ABP— 314485-22

Planning Appeal Online Observation

Case Number / Description
314485

Dublin Airport, Co Dublin

Figure 3-3 Annual Traffic Impact Summary (millions of passengers) (Mott McDonald, 2020)

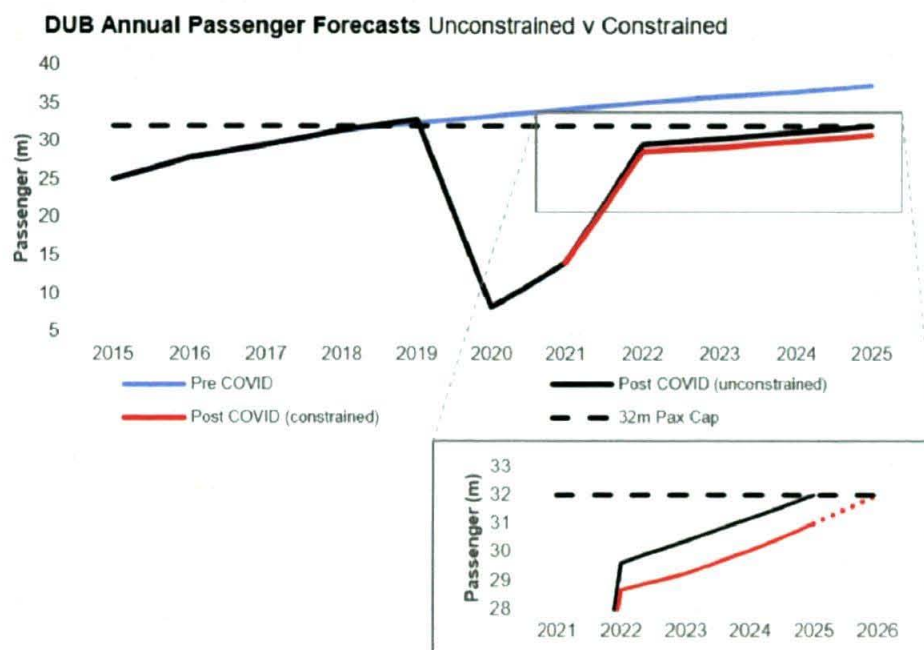
- Mott MacDonald report shows that the daa can achieve **42m** Passengers in 2040 **whilst keeping restrictions**, providing proof that the objectives of the National Aviation Policy (2015) can be achieved whilst protecting the health of residents.

- The daa's figures for the number of movements lost up to 2025 are grossly overestimated by not fully utilizing the available 65 movements limit.
- daa's forecasts show ample capacity between 07:00-23:00 to cater for increased passenger numbers.

- In their Tap 2028 Prospectus the daa outline risks related to the North Runway. It discusses the two planning conditions, namely condition 3(c) and 5. It states that the current estimate of a decision from Fingal County Council is quarter 3, 2022. And if the decision is appealed, a decision from the appeals board is anticipated in quarter 1, 2024. Therefore, the loss of passenger numbers presented in the Mott MacDonald report are unrealistic as the planning conditions will not be amended before then. The Mott MacDonald figures are theoretical and inaccurate.
